**KIRKLEES METROPOLITAN COUNCIL
INVESTMENT & REGENERATION SERVICE**

Reference No:	2024/62/91347/W
Site Address:	15, Colwyn Street, Marsh, Huddersfield, HD1 4PF
Description:	Erection of single storey side and rear extensions with front and rear dormers
Recommending Officer:	Laura Yeadon

Officer Report

A1-CAD/03

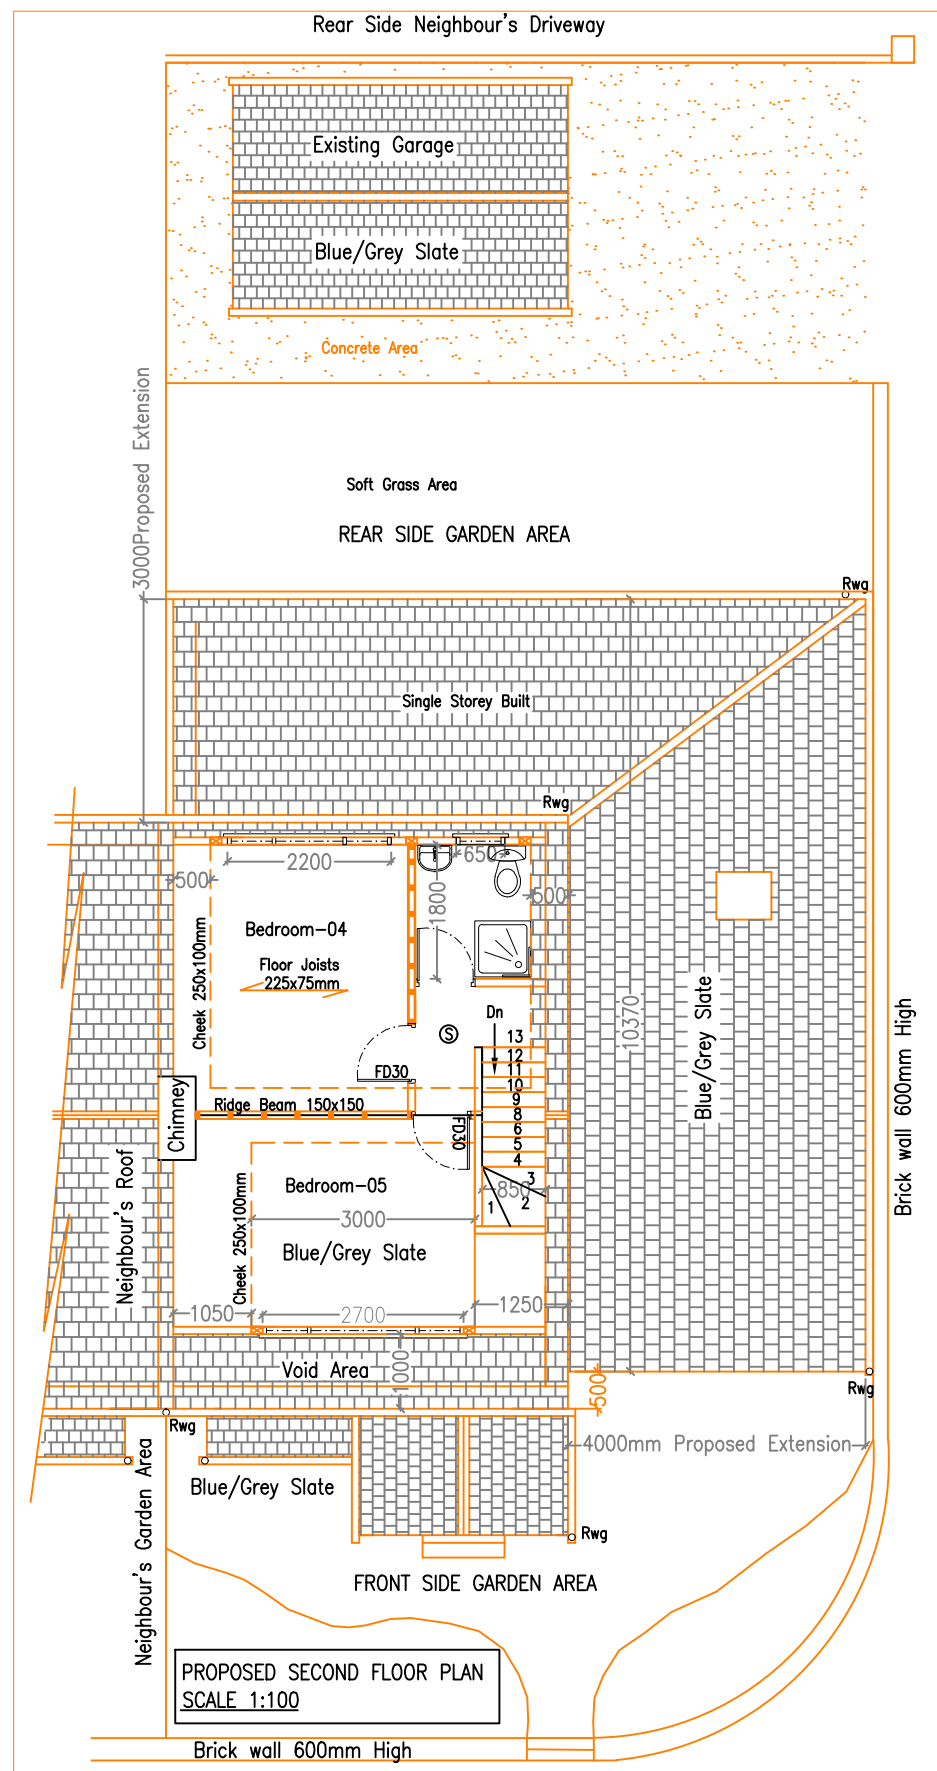
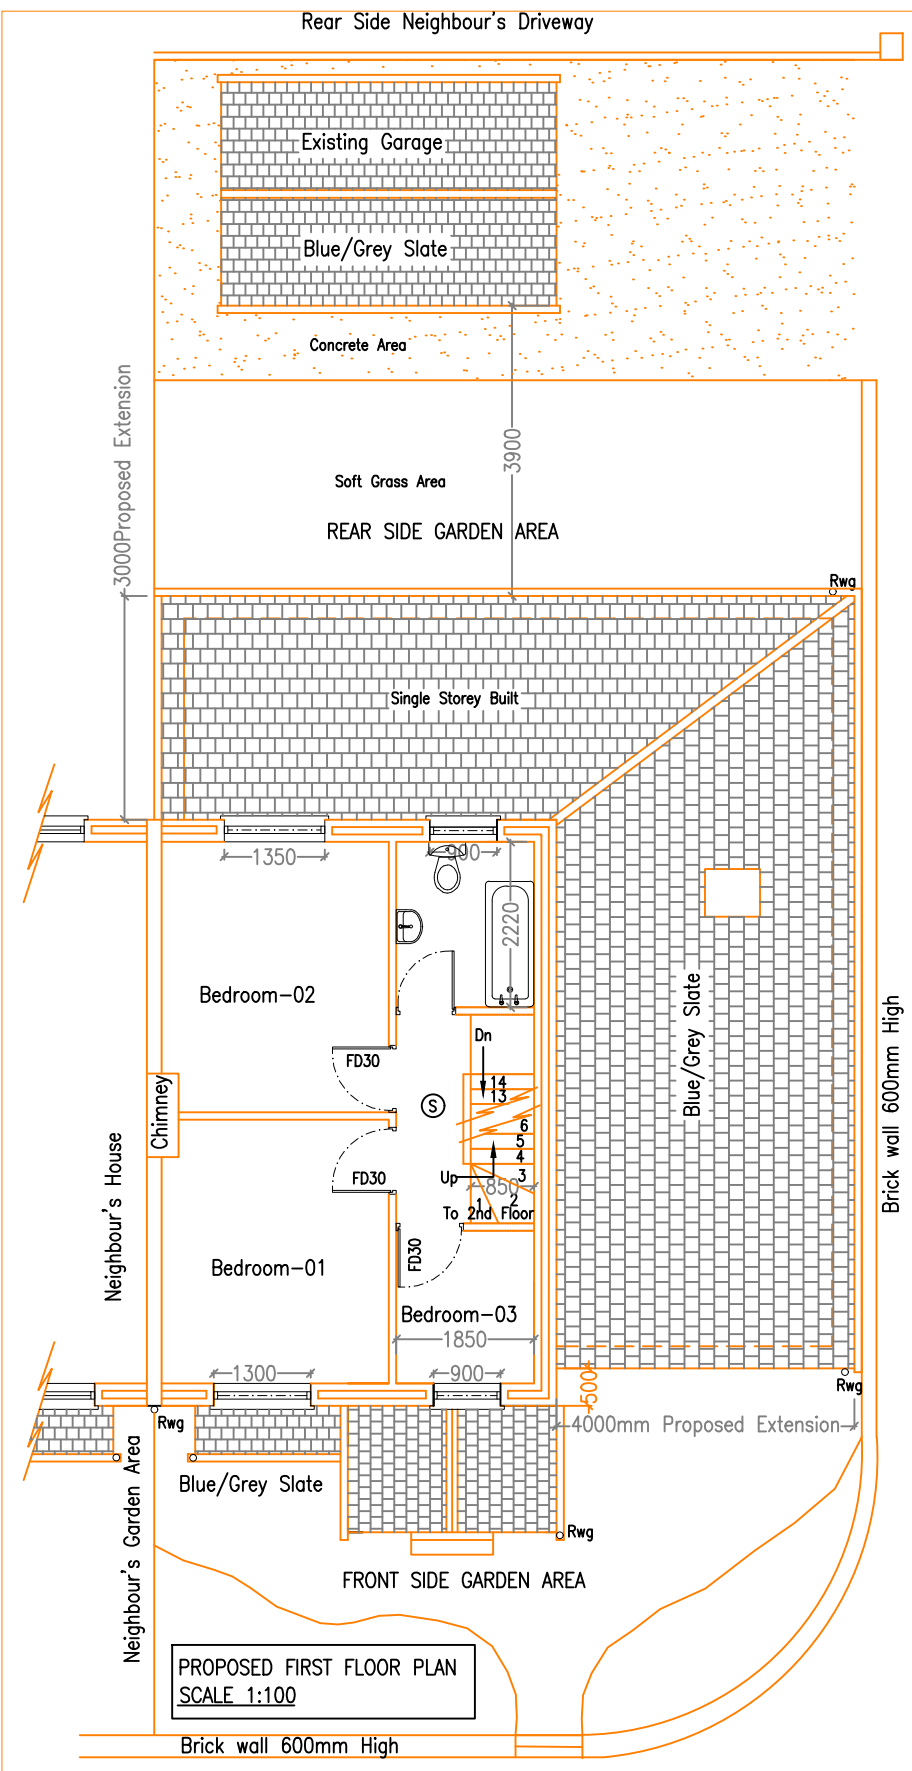
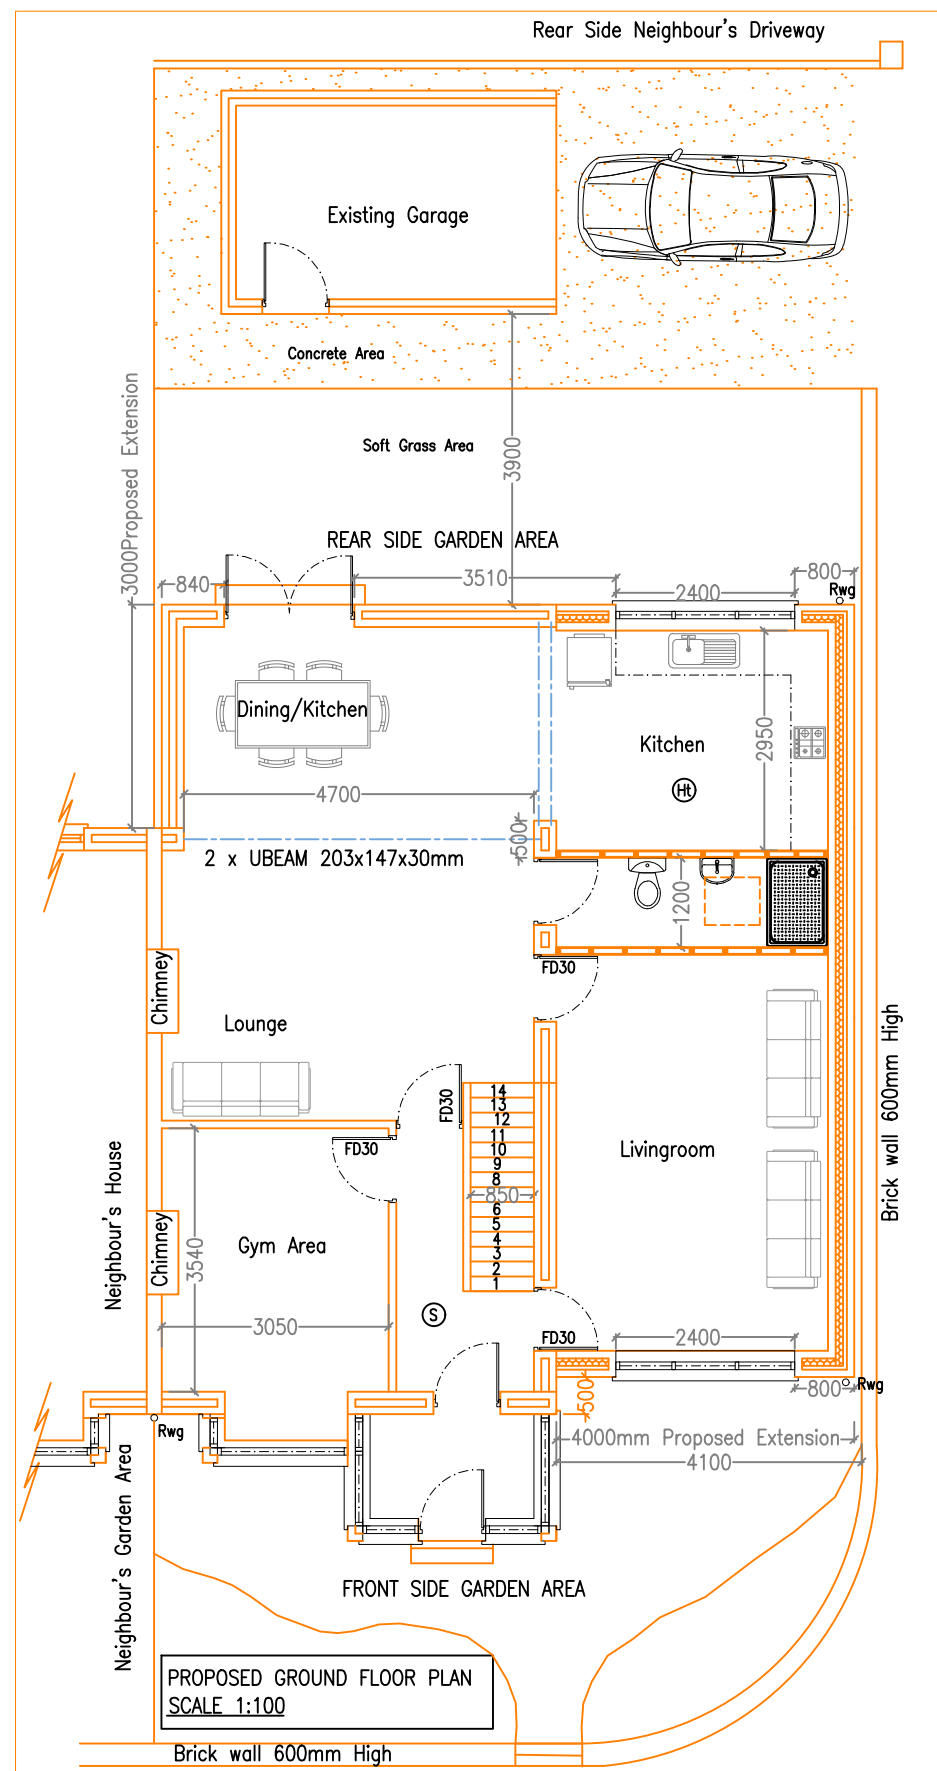
In this case the submitted plans indicate that the property would result in a 5 bedroom dwelling as the bedroom numbers are annotated on plan. The SPD requires that for 4+ bedroom dwellings require 3 off-street parking spaces. The property benefits from a driveway to the rear which can accommodate a car and garage provision. Concerns were raised as the garage provision falls short of the modern standards in terms of dimensions and therefore, there would be a shortfall of 2 no. off-street parking spaces. In response, the applicant has submitted justification with regard to parking standards.

On-street parking is available within close proximity of the site and the property is within a sustainable location and therefore, in this instance, it is not considered that the resultant works would cause significant harm to highway safety or on parking provision. Weight is afforded to the level of works which could take place in any event, having regard to the planning history of the site / permitted development rights which could be utilised.

PROPOSED REAR WEST SIDE ELEVATION
SCALE 1:100

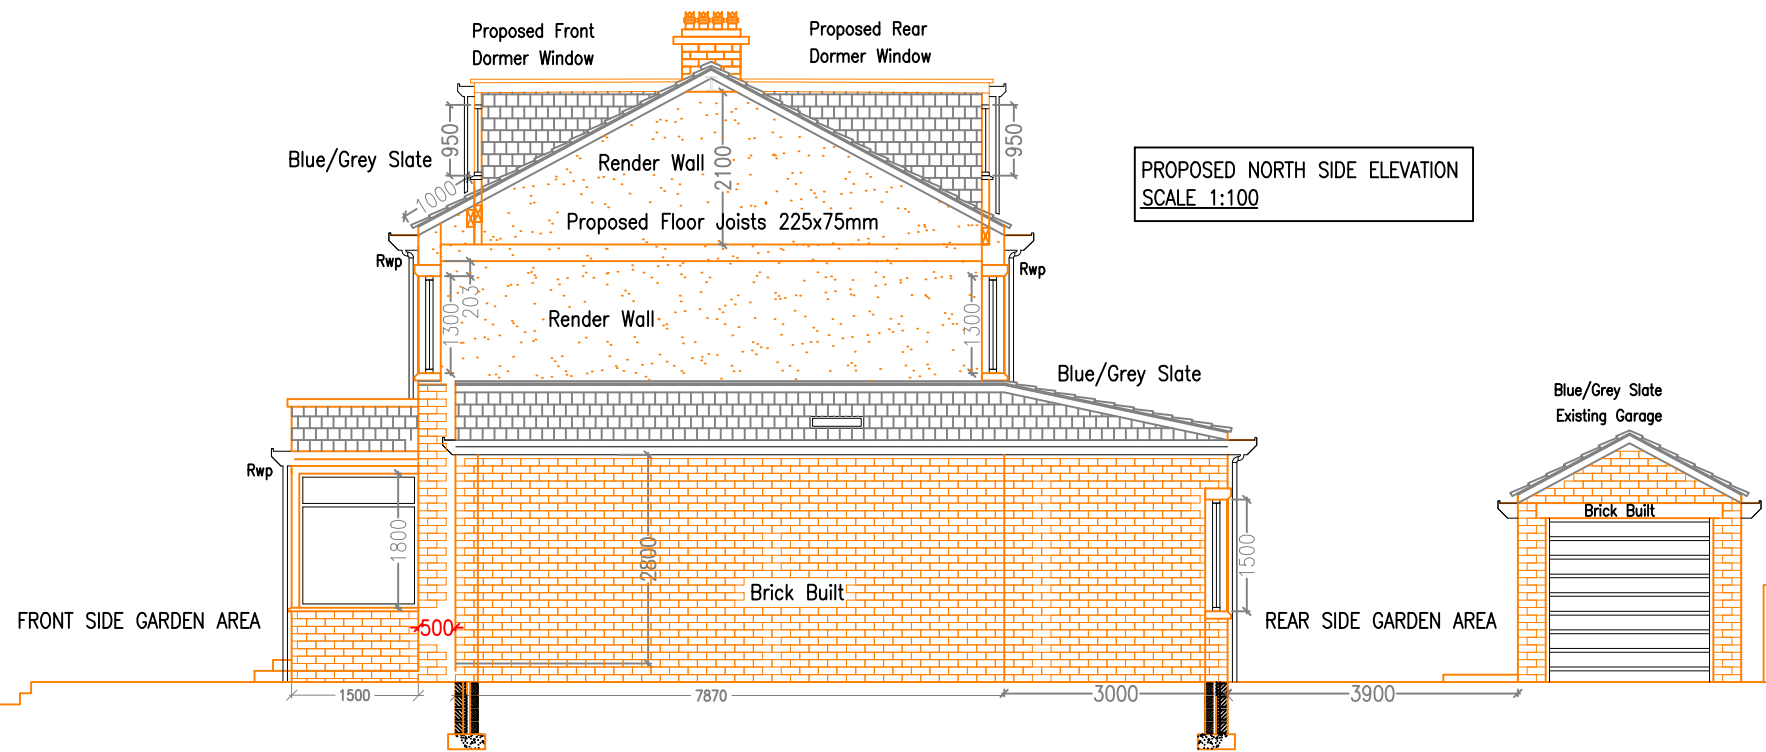
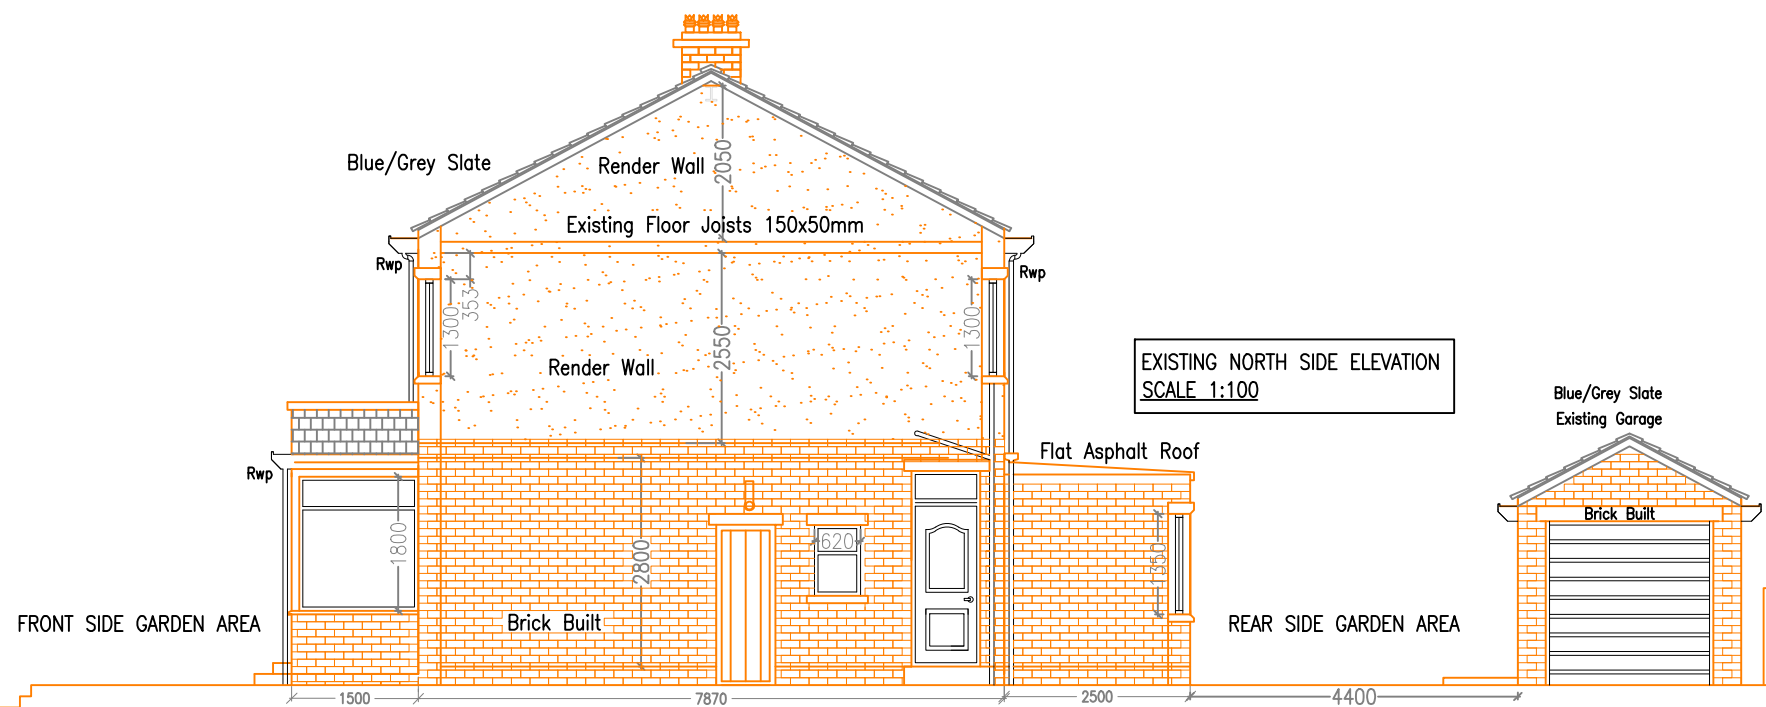
In terms of the proposed rear extension this would extend behind both the original property and the proposed extension with a projection of 3 metres. The extension would be subservient to the host property being single storey in height and, taken in isolation would not cover more than half the total area around the original house. The height of this element of the scheme would not

exceed 4 metres. Whilst the rear extension would not retain a 1 metre gap between the shared boundary with the attached neighbouring property, it is important to note that permitted development rights for the construction of extensions have not been removed from the property and therefore, a 3 metre projecting extension built up to the boundary could be constructed without the requirement of planning permission, subject to conditions. Therefore, it is not considered that the proposed rear extension and side extension, forming a wraparound extension would cause such harm to the visual amenity of this residential area to warrant refusal in this case.
